5 May 2019

**RETROSPECTIVE APPLICATION FOR DISPLAY OF ADVERTISEMENTS
THE BREWHOUSE (Former Crossbush Farm Shop) LYMINSTER ROAD, LYMINSTER
APPLICATION REF LY/8/19/A**

North Elevation

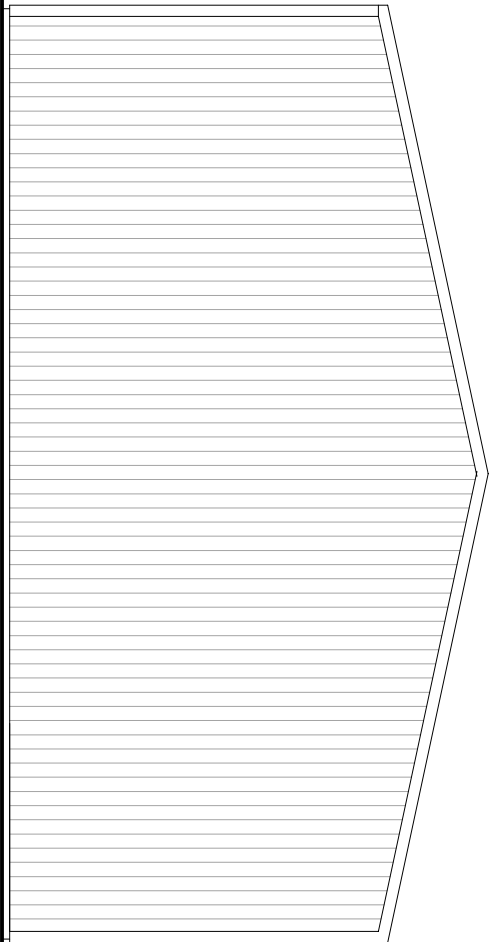
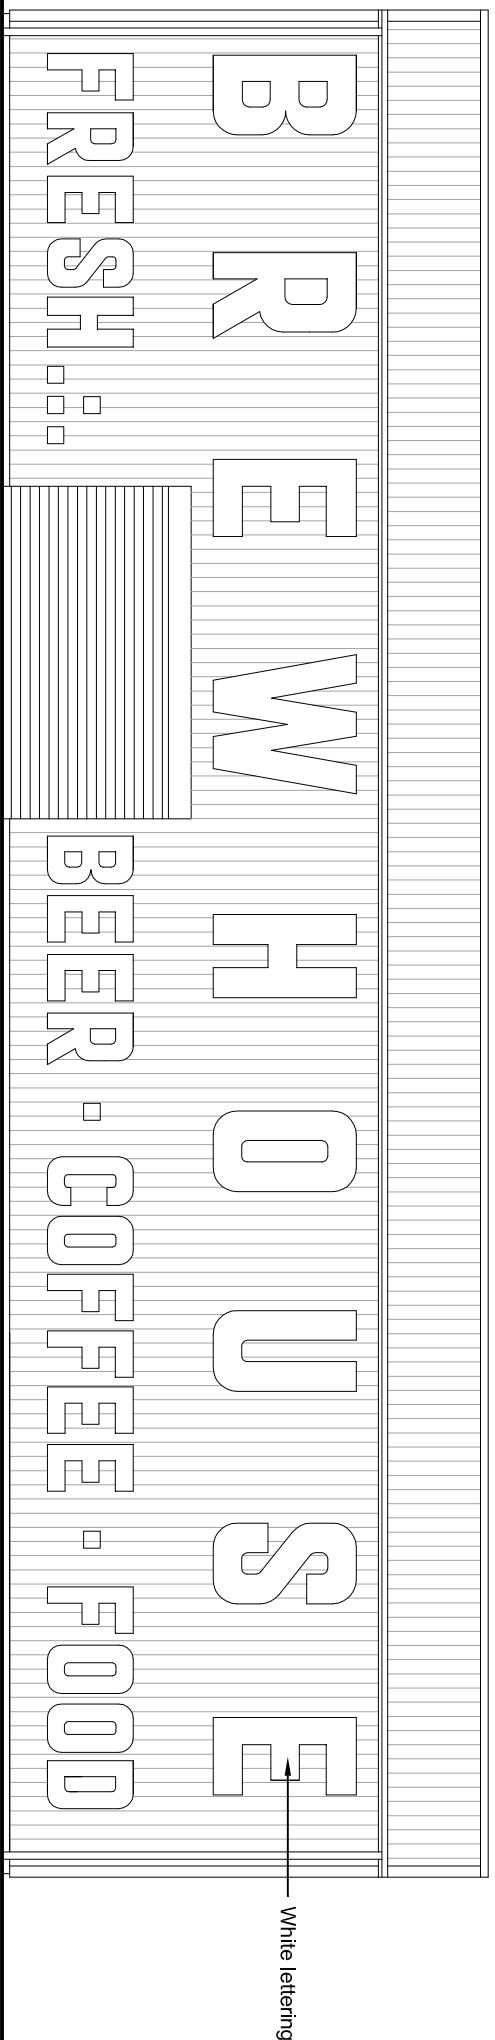
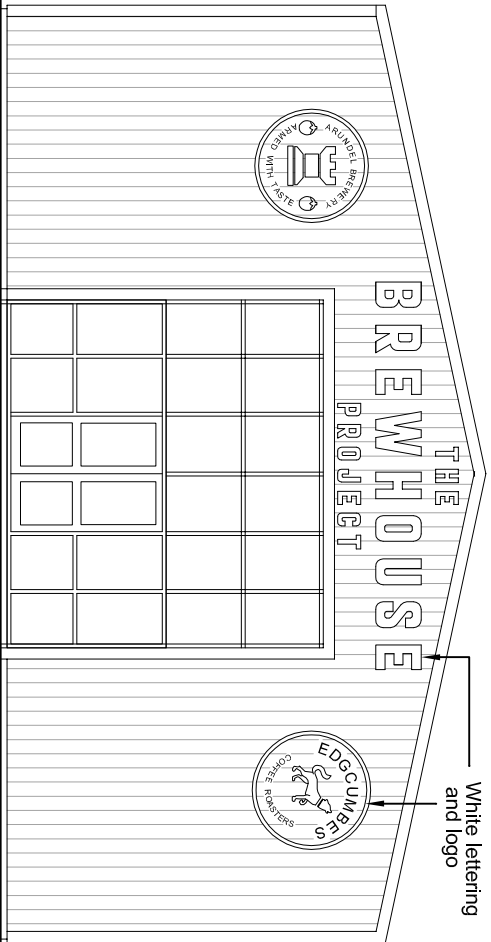
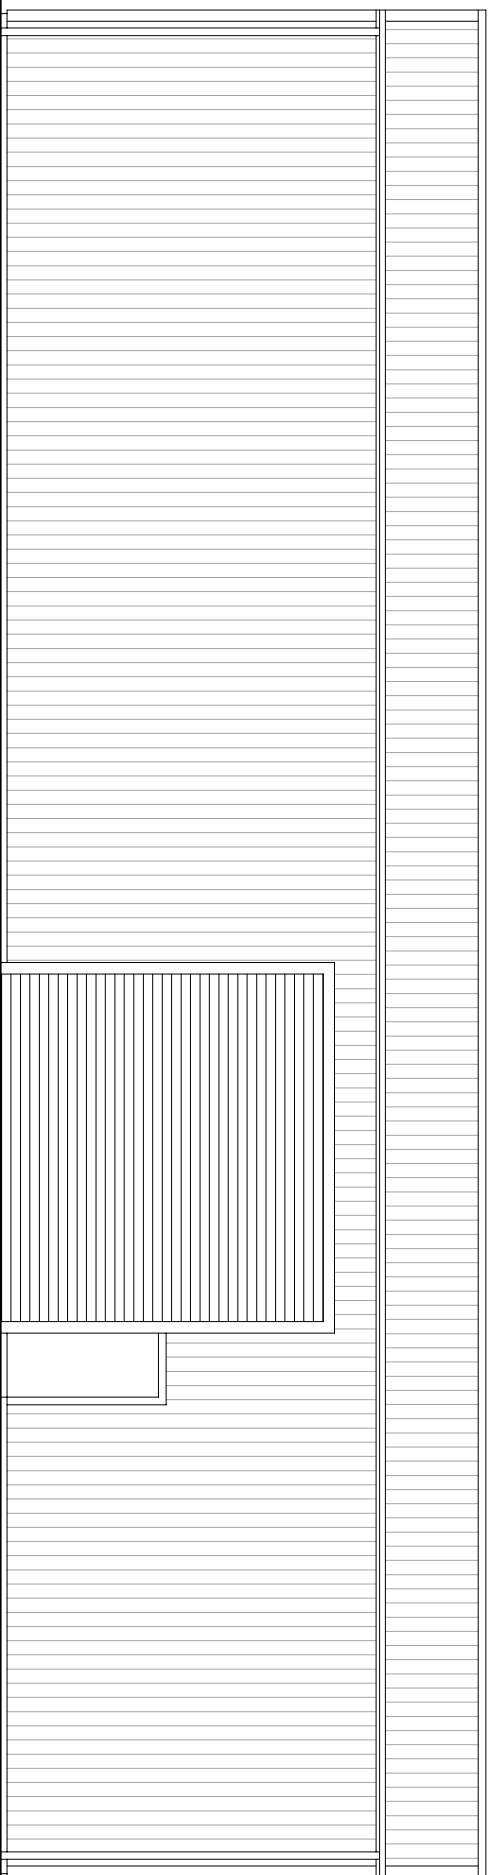
- The "BREWHOUSE" lettering is around 2 metres in height and extends to around 23 metres in width across the whole of the north elevation. Its scale and stark white colour on the black background of the building, means that it is especially prominent.
- The lettering is highly prominent and intrusive in views of the building, particularly from the north, where countryside policies apply.
- The display is also visible from within, and detrimental to the appearance of, the South Downs National Park, the boundary of which is close-by.
- The applicant's supporting statement explicitly acknowledges the prominence of the signs and comments that the deliberate intention is for these to be highly visible from the A27.

The lettering applied to the north-facing façade of the building is also such as to give rise to substantial risk to public safety in the following ways;

- This visibility arises at a point where high-speed westbound traffic should be slowing in the approach to the sliproad, roundabout and traffic signals, at the junction. This requires that drivers' attention is not diverted by advertisements at the building. These are distracting features in a driver's peripheral vision, likely to lead to momentary inattention with highly dangerous potential consequences.

For these reasons the signs, especially those on the north elevation of the building, cause distraction to drivers, contributing significantly and unacceptably to the risk of accidents. In this way, the retention of the unauthorised advertisements on the north elevation of the building would compromise public safety.
